Demolition of existing dwelling & the erection of 7No. residential dwellings, with associated parking, amended access location from Lime Tree Close & landscaping.

Scorton 9 Lime Tree Close East Preston

Thank you for your internet representation made on 16th May 2018 which has been recorded as **'an objection'** with the comments as follows:

The Pure Group
Limetree Close East Preston
Plot 4: Limetree Cottages. Proposed Elevations, Floor Plans, Roof Plan & Section
Drawn by: AM The Pure Group
Drawing ref: LTC.PLOT4.001
Planning Issue: March 2018. Scale as Bar
www.thepuregroup.info

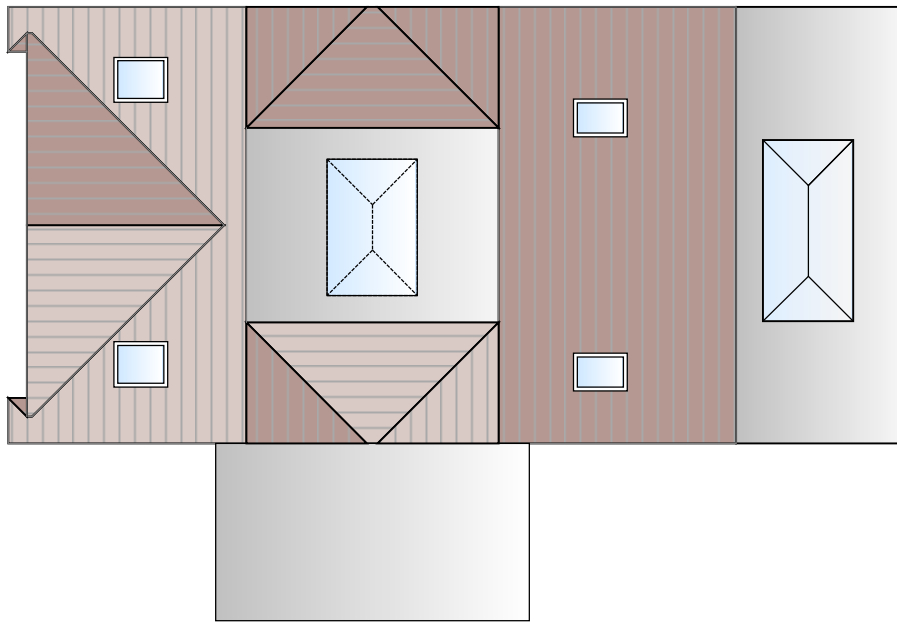
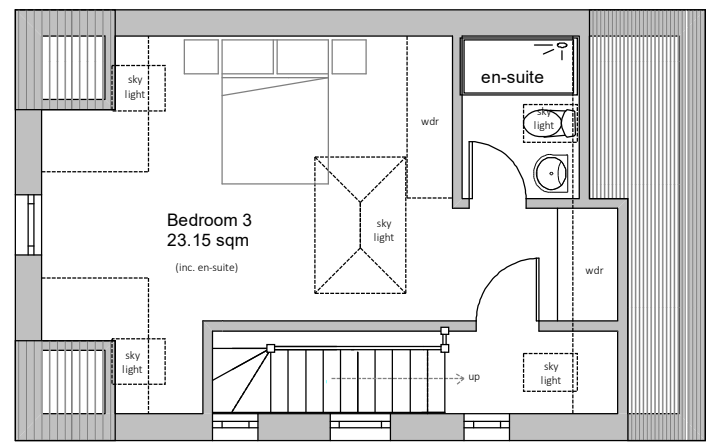
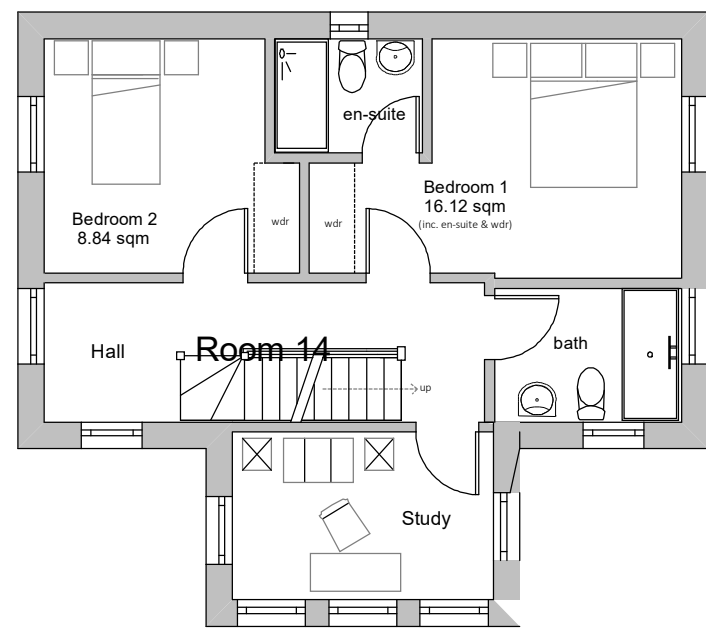
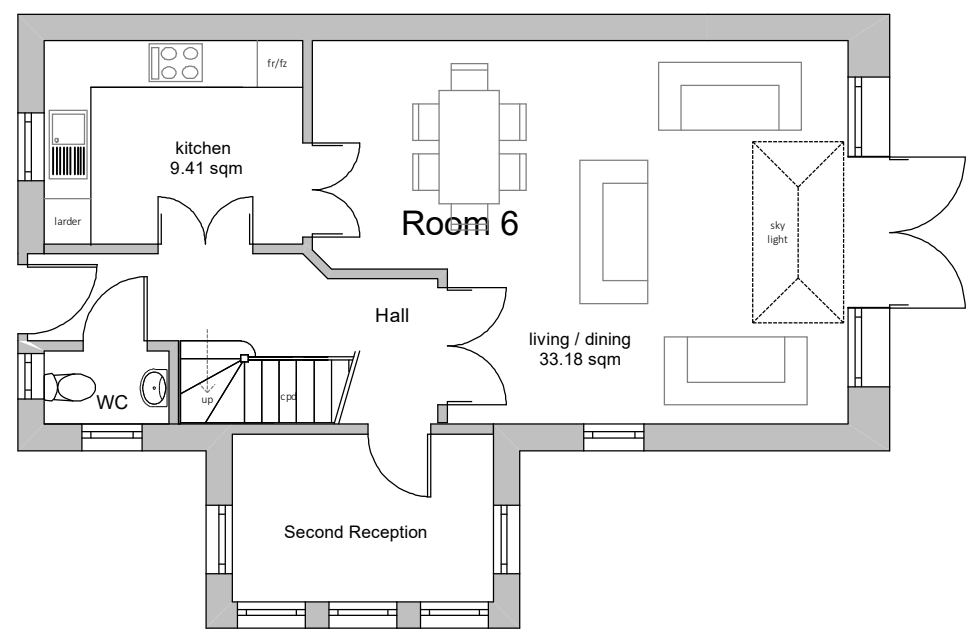
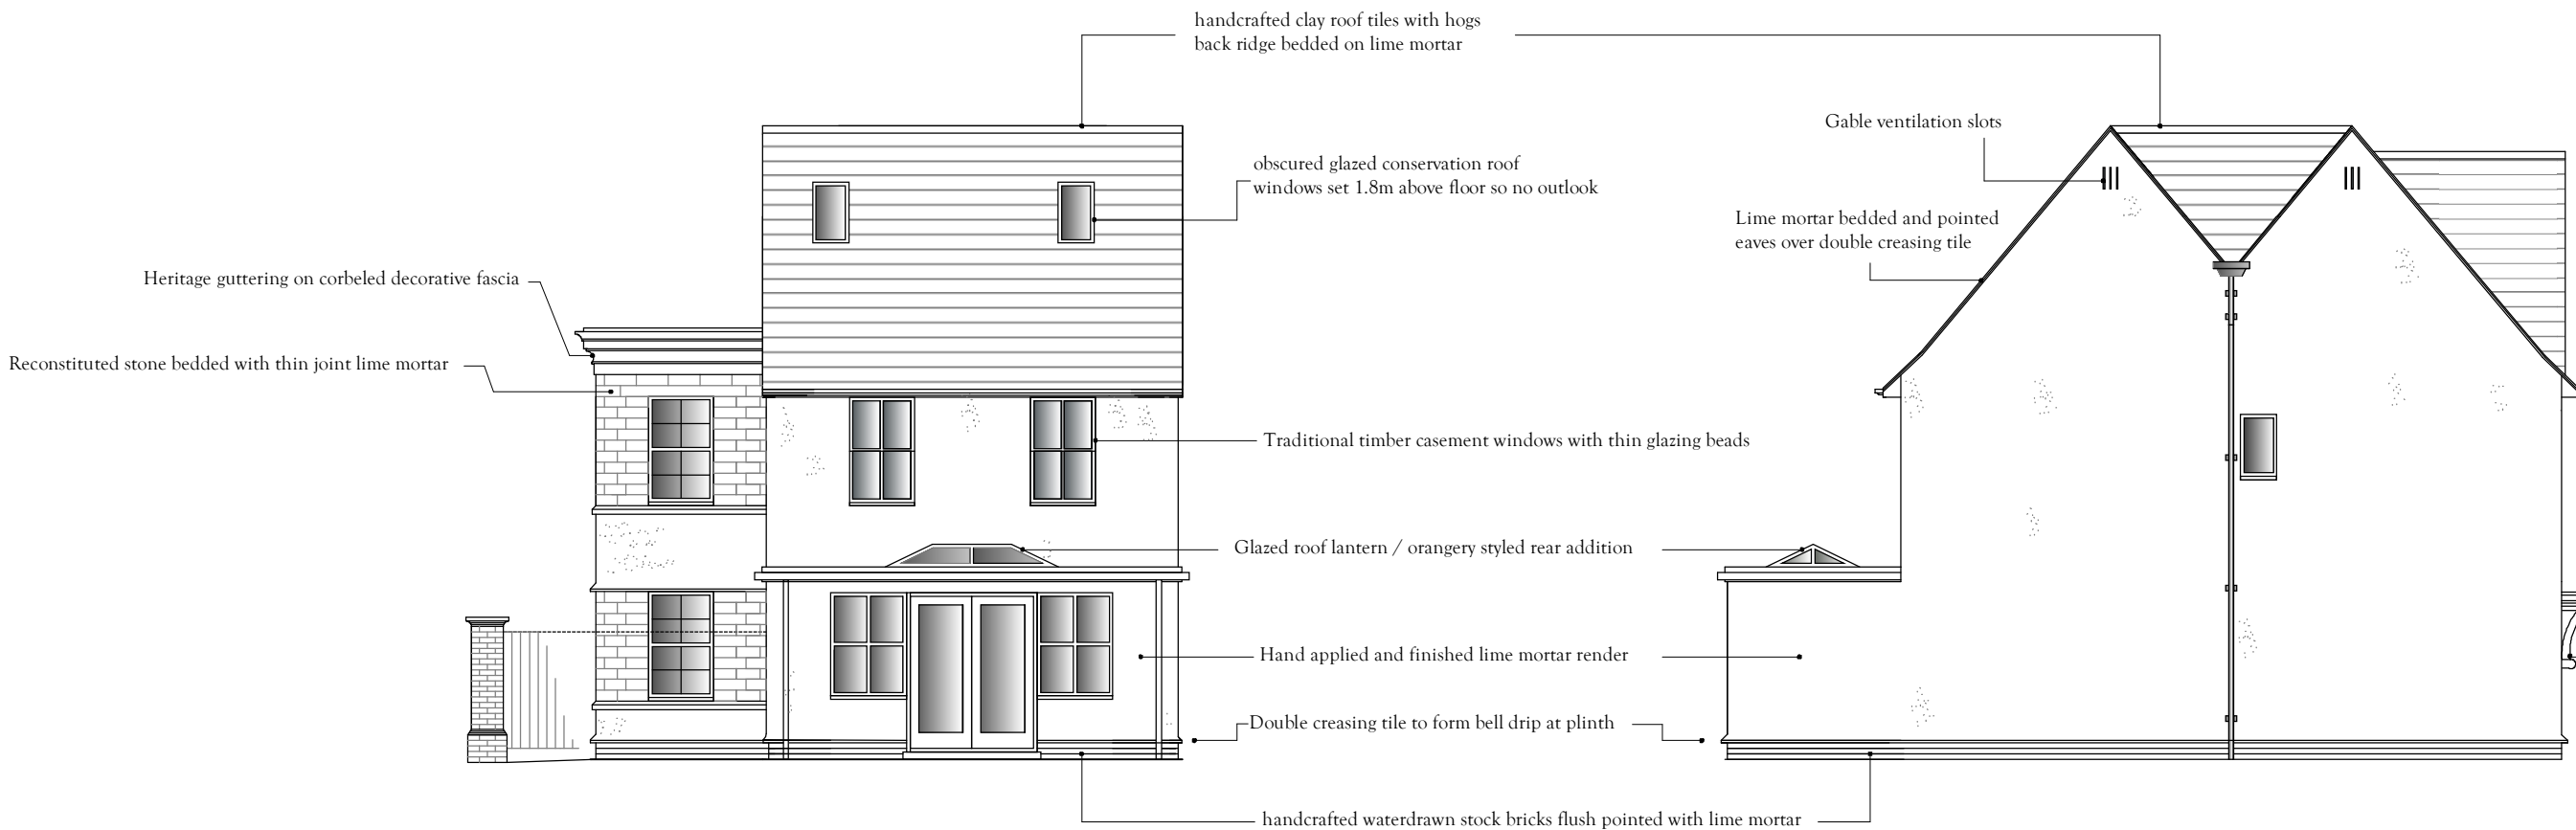
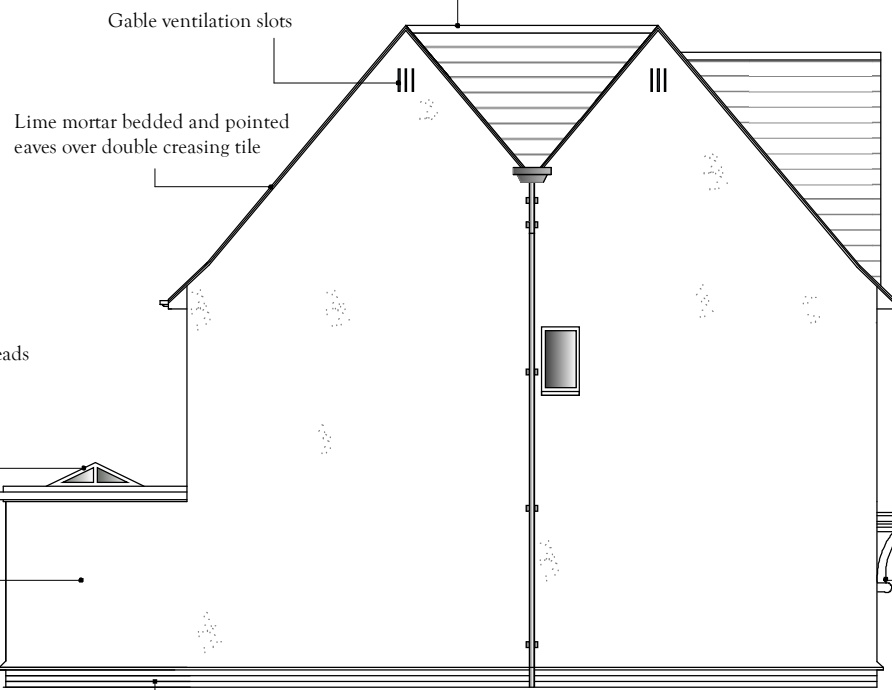
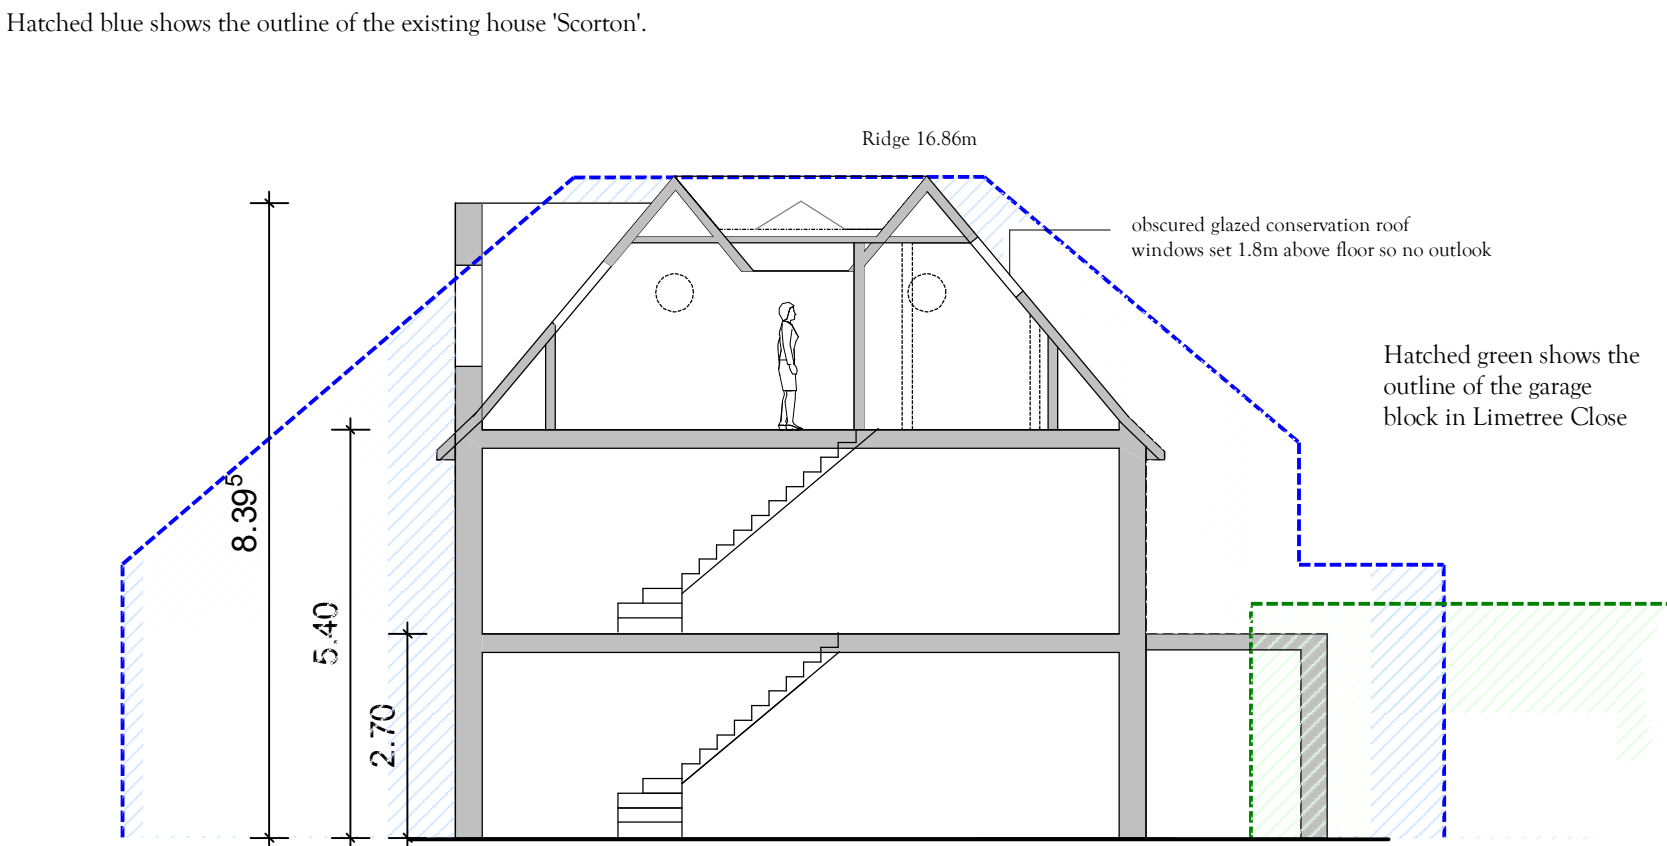
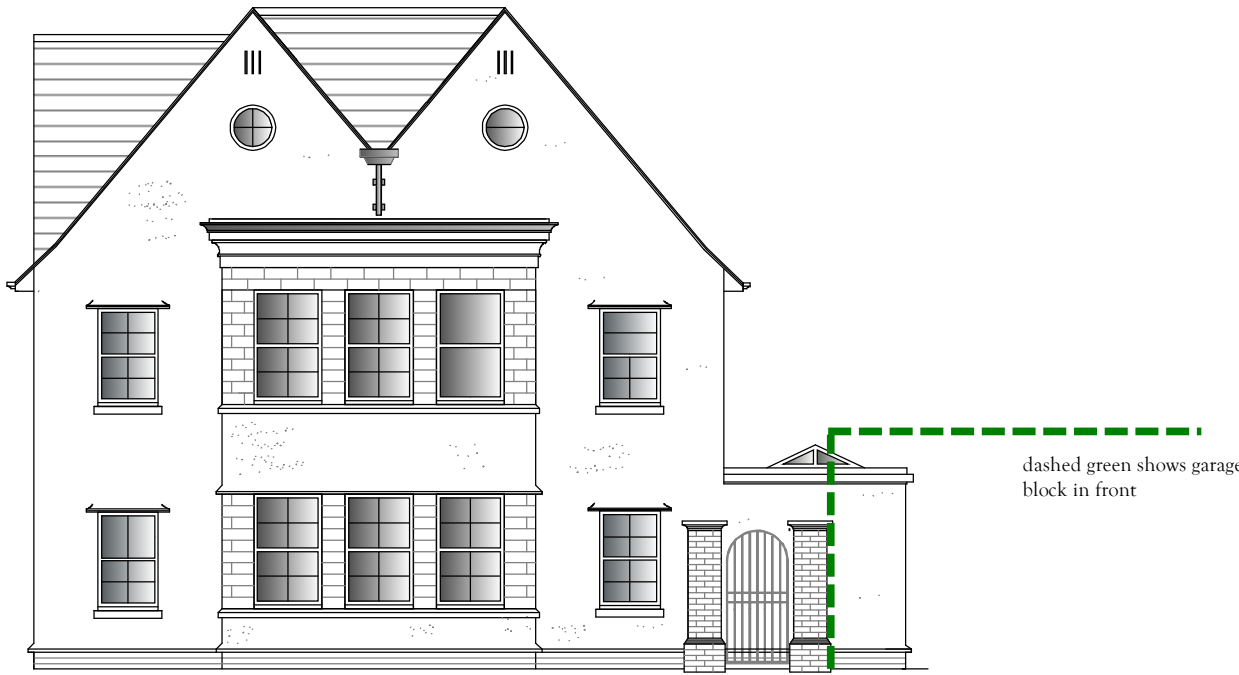
On a different subject, the PLAN for Plot4 show the house design for Plot 7 and the PLAN for Plot 7 shows the house design for Plot 4. This is misleading. Plot 4 is very different from plot 7 in that it has a two storey extension to the south side.

When I first looked at the Plans, I didn't know there would be another window from the study of this extension overlooking me and could have missed the opportunity to object. Can I ask that this be corrected and that in future details are checked before they are made public.
